Your Ref: OWPC21467
Our Ref: FP/274/18/PL 19-12-2018
Please ask for:
Richard Castro-Parker

Demolition of 1 No. house & erection of 2 No. detached chalet style dwellings with
garaging & car parking.

10 Felpham Gardens Felpham

Thank you for your internet representation made on 13th February 2019 which has been
recorded as '**an objection**' with the comments as follows:

EXISTING PLOT PLAN

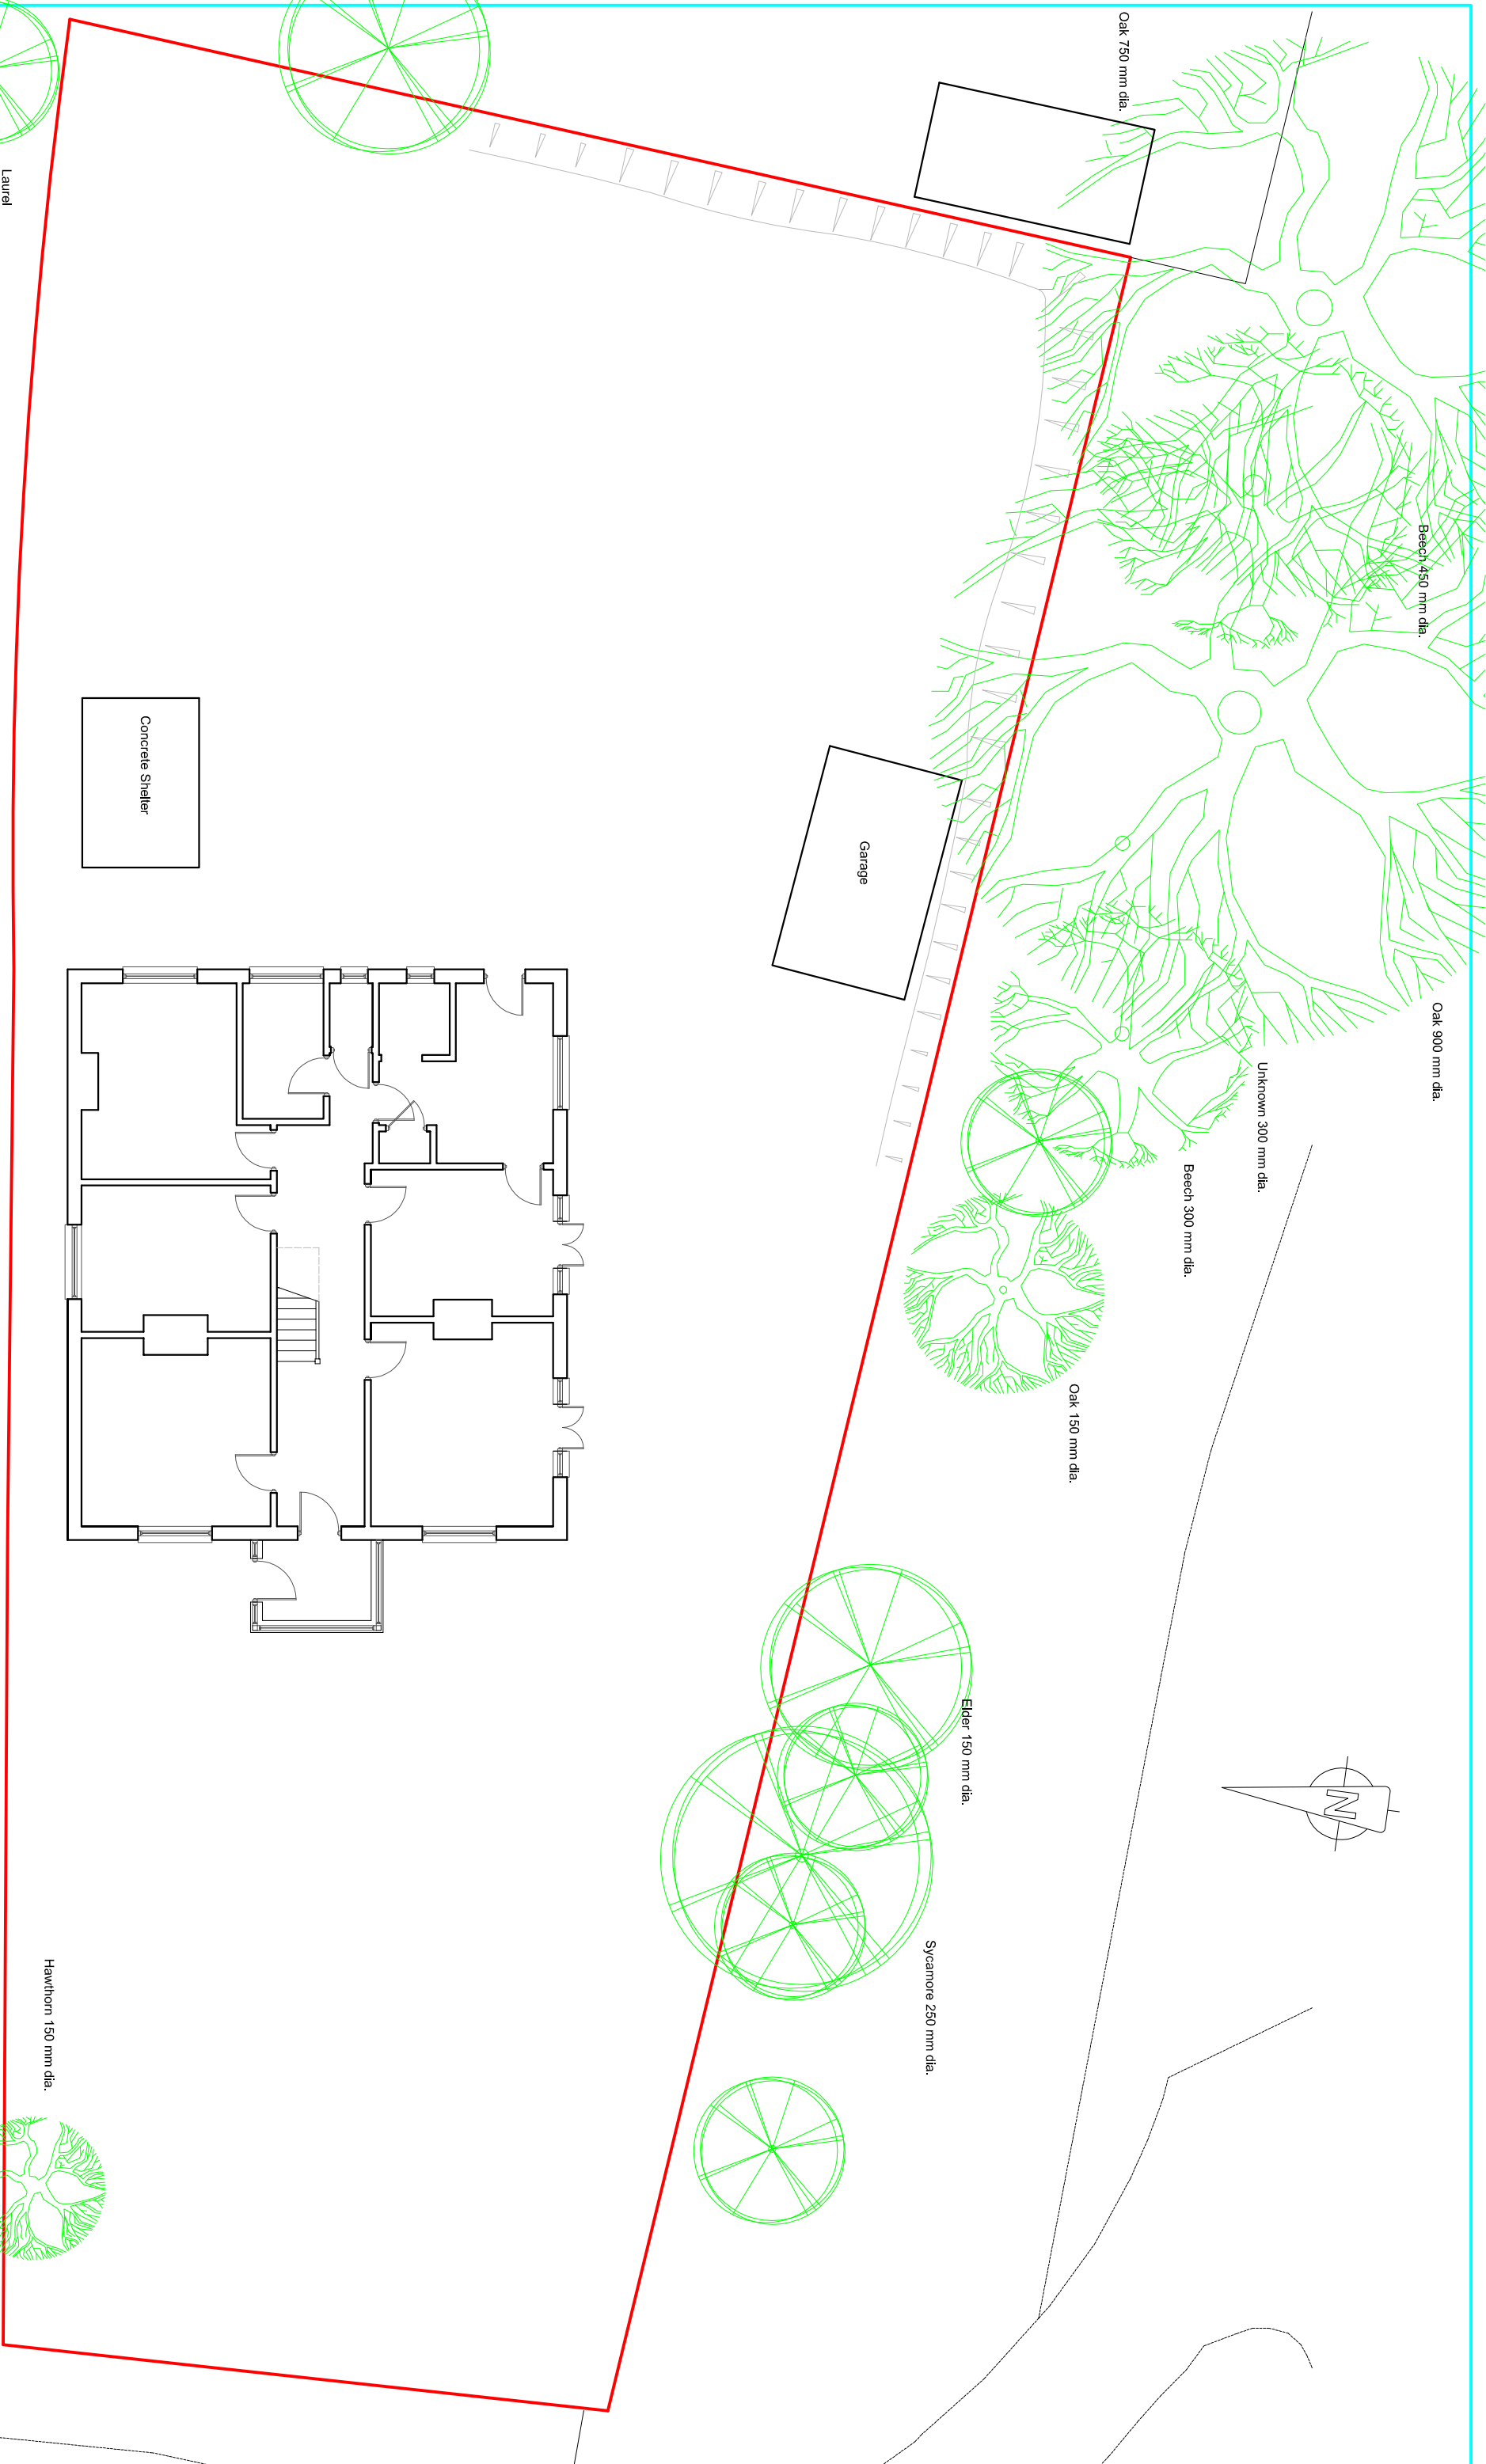
*Submission of planning application which fails to reference that approx 7 mature trees
were removed from the site immediately prior to the plan being submitted;*

PROPOSED PLOT PLAN

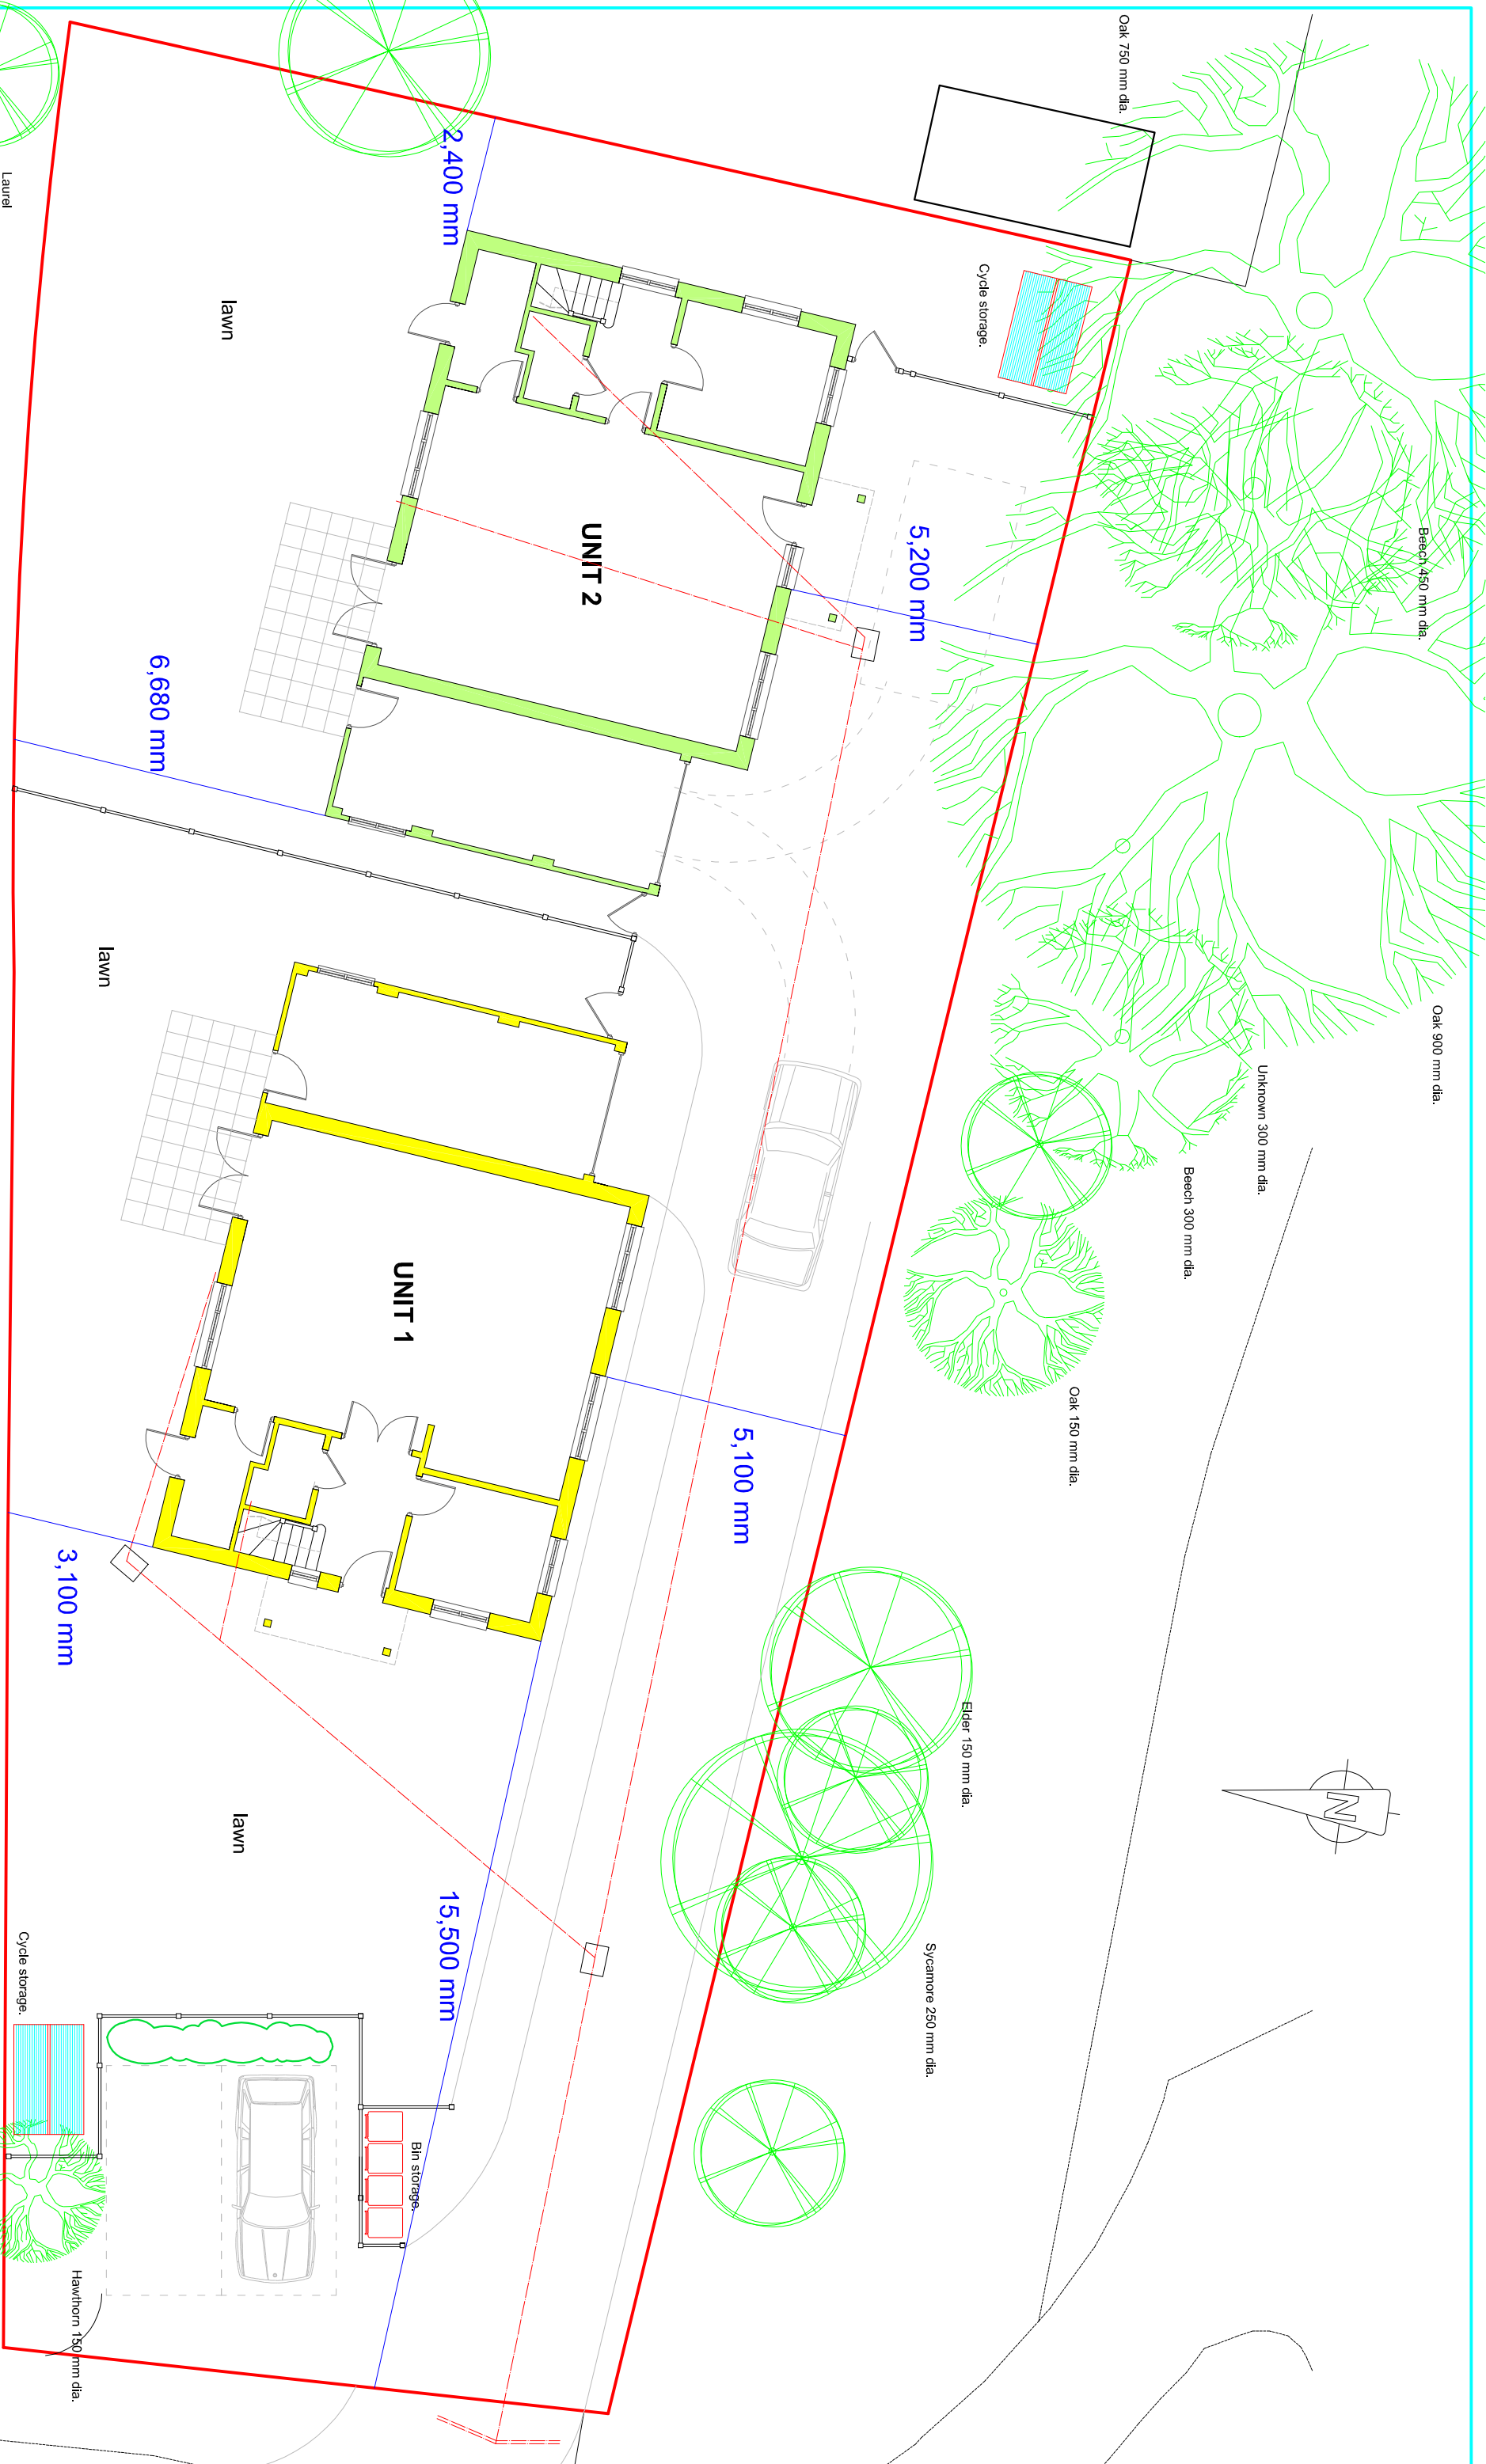
*Inaccurate outline plan of the site especially where the drive meets Felpham Gardens and
the proposed space for off road parking;*

*To maintain alignment with the frontage building line along Felpham Gardens - the
proposed "marginal" amount is too loose a description and frequently disregarded in the
building trade and, from the plan, it is clear that to enable the construction of two buildings
on the plot, the front building line will have to be moved forward significantly from the
current building line. In reality, to ensure and maintain integrity of the building line, there
should be no variance from the current building line along Felpham Gardens.*
